Your Ref: OWPC23340
Our Ref: LU/126/19/PL
Please ask for:
Mrs A Gardner

Demolition of the existing garage building (B2 industrial use) and redevelopment of the site providing 9no C3 residential units - This application affects the character and appearance of River Road Conservation Area.

25 River Road Littlehampton

Thank you for your internet comments made on 3rd June 2019 which has been recorded as **'an objection'** with the comments as follows:

PROPOSED DRAWINGS:
Terminus Place
Proposed & Existing Street Scenes

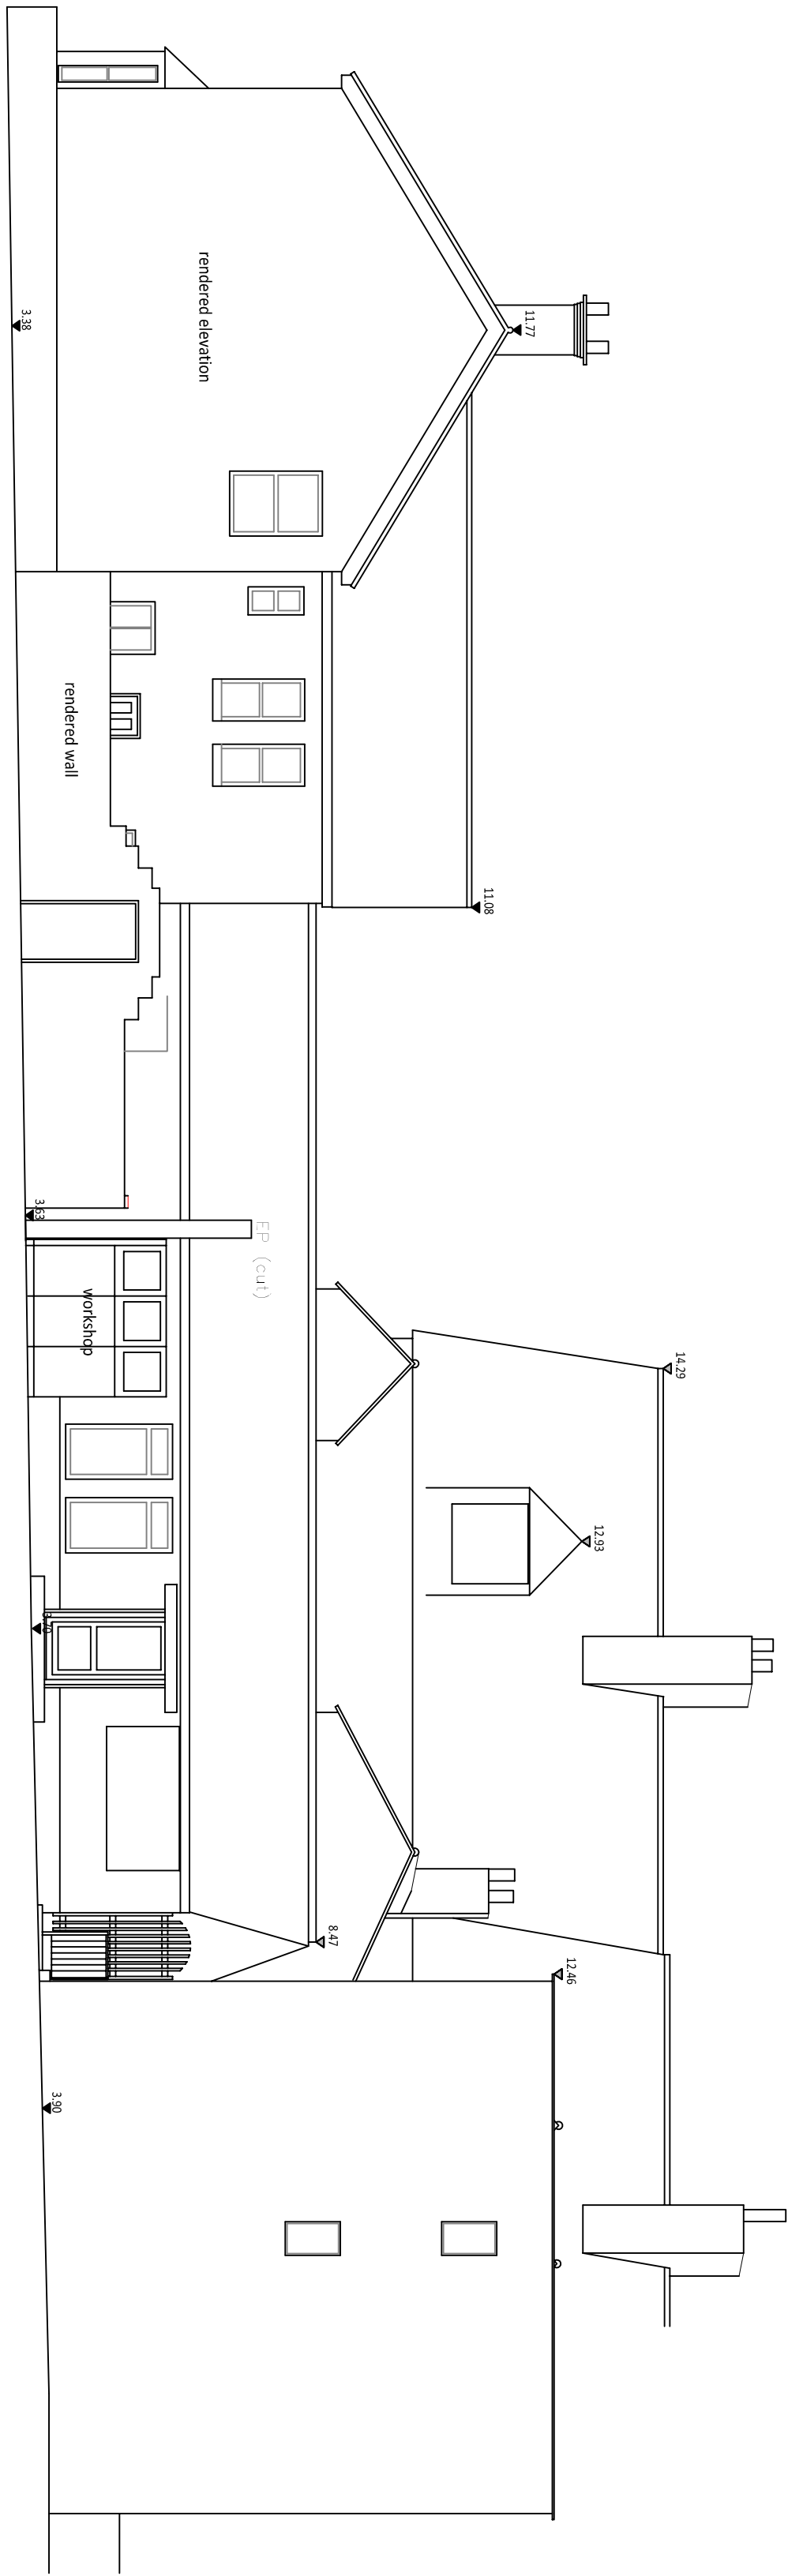
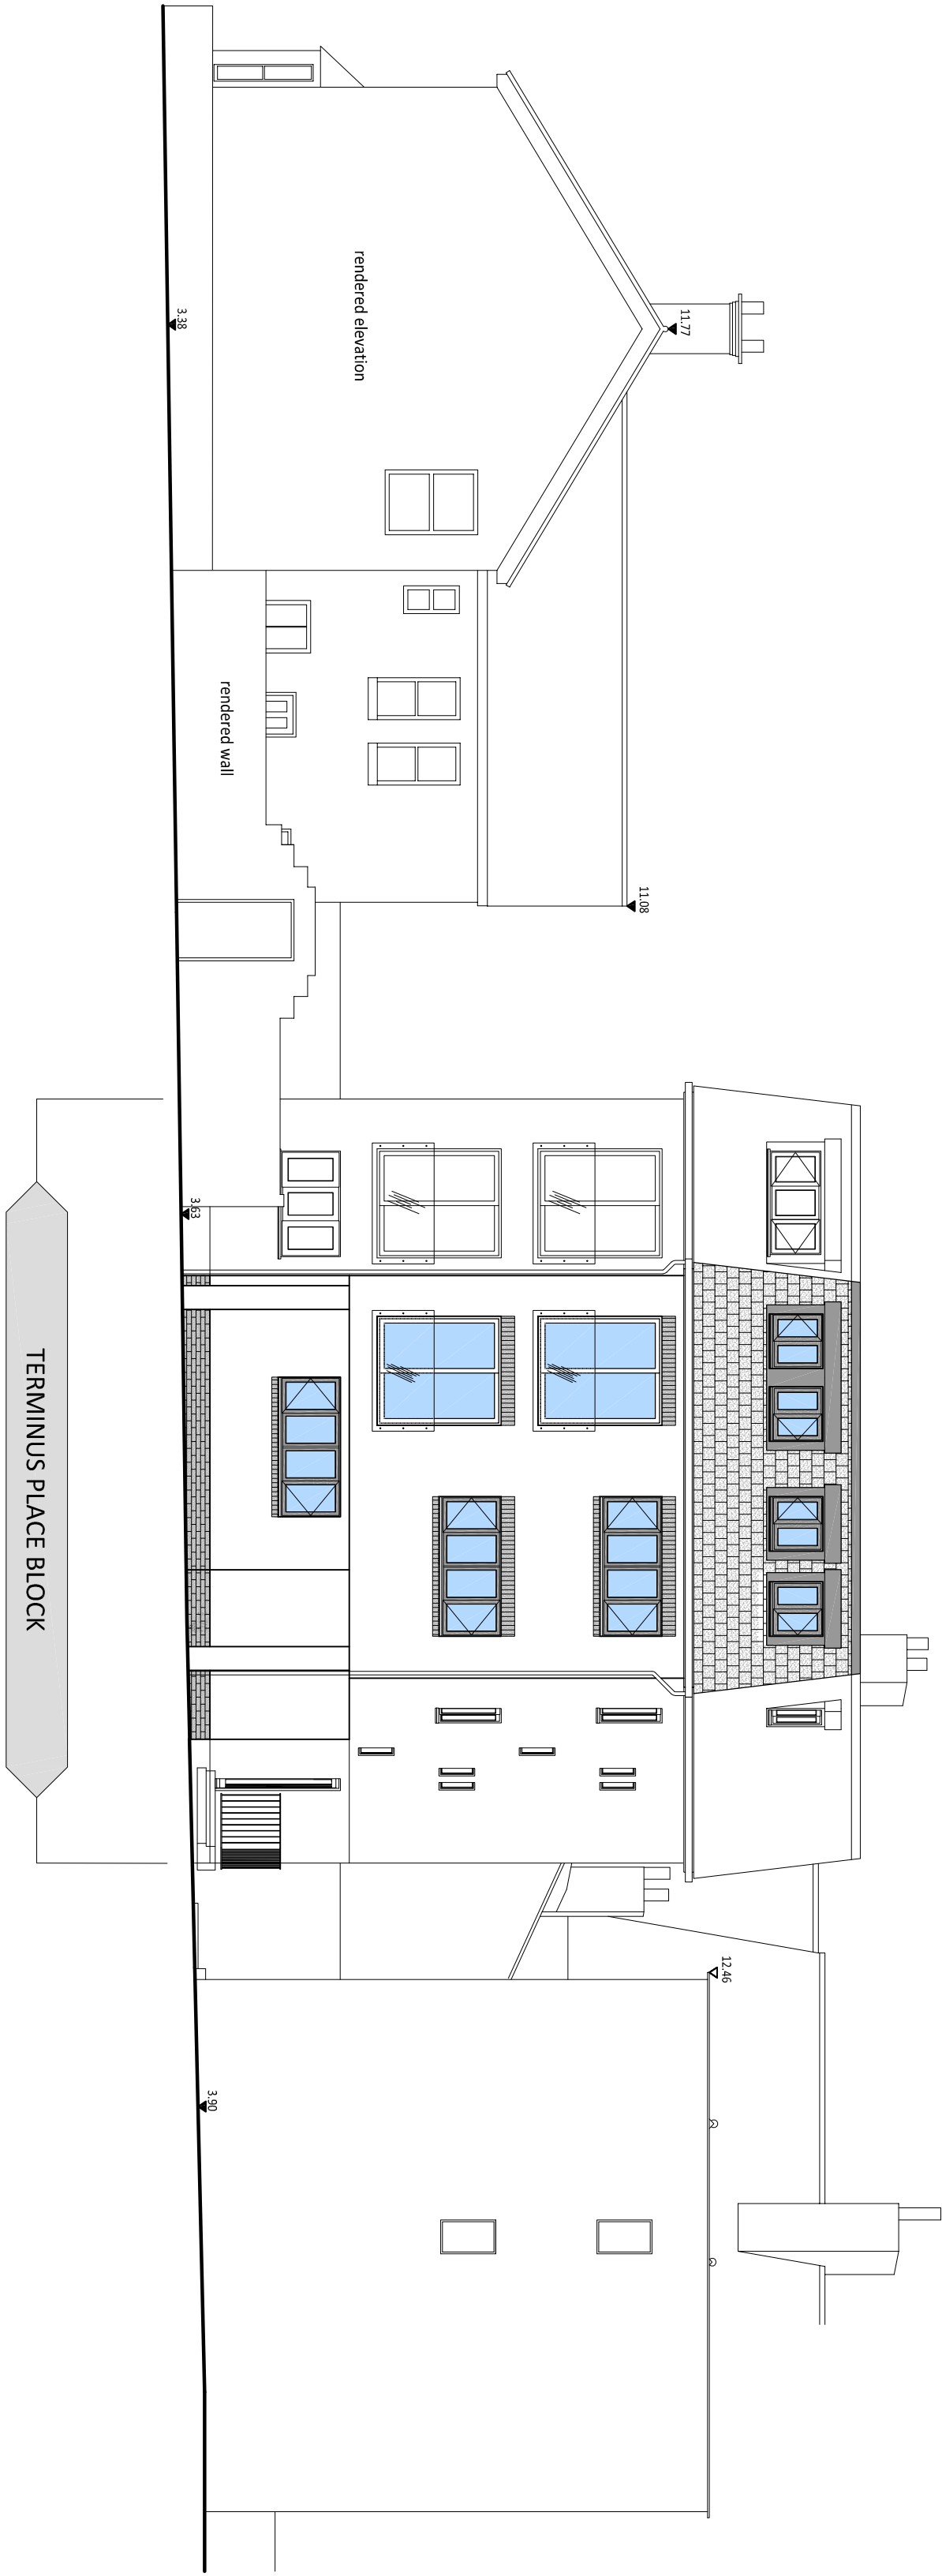
The Town Council's Planning and Transportation Committee considered this matter at its meeting held on 28th May and object to the application on the grounds that it is an overdevelopment of the site; The design appearance and scale of the development in Terminus Place was thought to be overbearing; car parking would be a significant problem which combined with the lack of provision for cyclists was thought to have a significant impact on the highway (Terminus Place). There were also concerns about the likely increase in antisocial behaviour. The appearance and scale of the River Road frontage was thought to be acceptable.
